## **Draft Statement of Common Ground with the Environment Agency**

# Helios Renewable Energy Project

Planning Inspectorate Reference: EN010140

February 2025

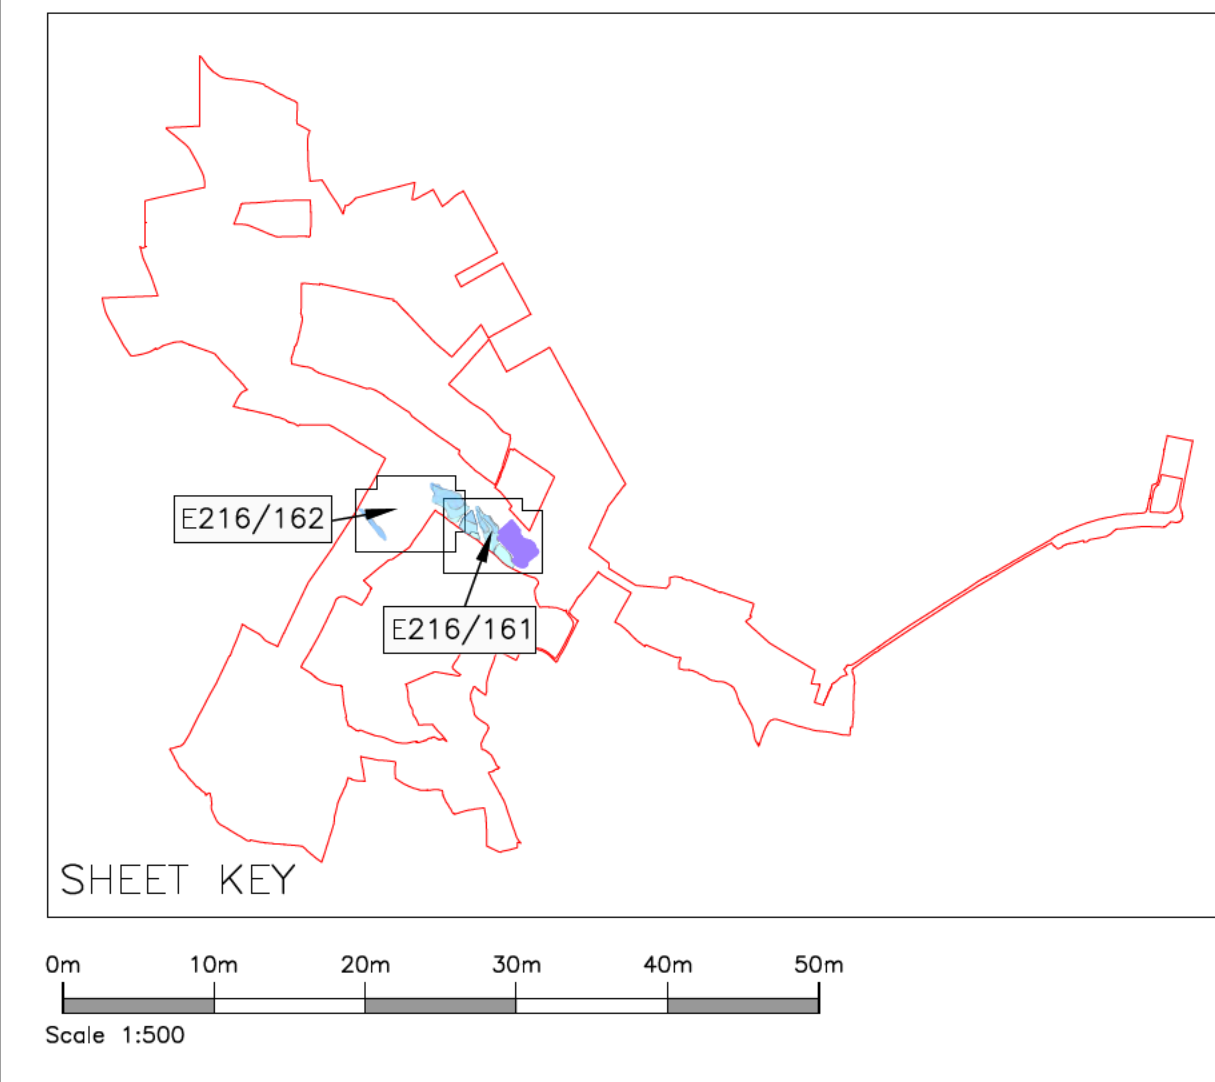
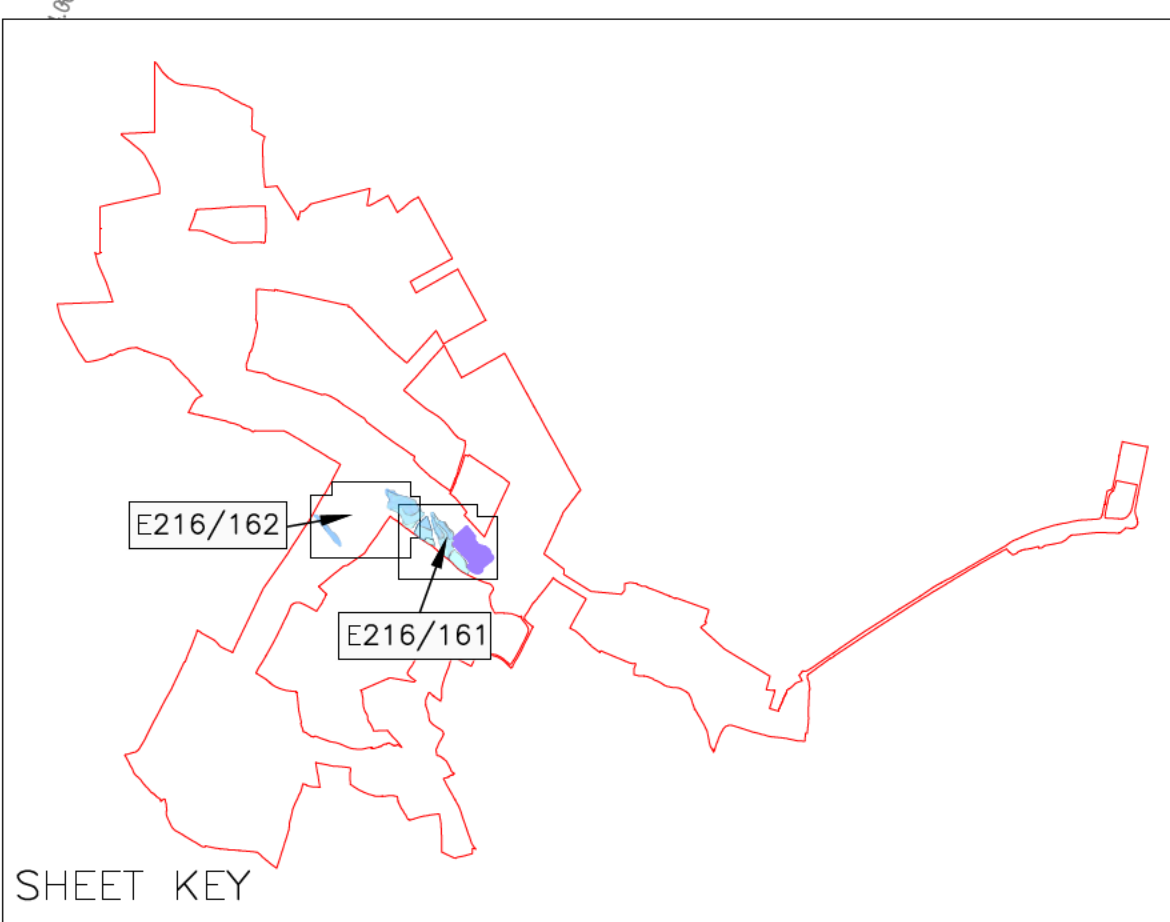
EA-05 [RR-117]	BESS floodplain compensation	In their RR, the EA stated that: <i>We require further detail as to how the flood risk compensation scheme as proposed in the Flood Risk Assessment will be secured to ensure this development does not cause flood risk elsewhere. This detail should include phasing of works to ensure that there will be no net loss of floodplain during construction.</i>	The Applicant is continuing to engage with the Environment Agency in respect of the flood management strategy and discuss the appropriate mechanism to secure this.	Under discussion
EA-06 [RR-117]	Operation of the development in times of flood	In their RR, the EA stated that: <i>No details have been provided covering operation in times of flood, to include clearance of debris and contingency in the event of failure of remote operation of solar panels.</i>  As per their D3 submission, the EA is satisfied with the assessment as provided in the Water Environment Supplementary Assessment, which will be included within the updated FRA.	The Applicant has addressed this matter in the Water Environment Supplementary Assessment (Document Reference 8.9) which will be submitted at Deadline 4. The FRA has been updated accordingly and will be submitted at Deadline 4.	Agreed
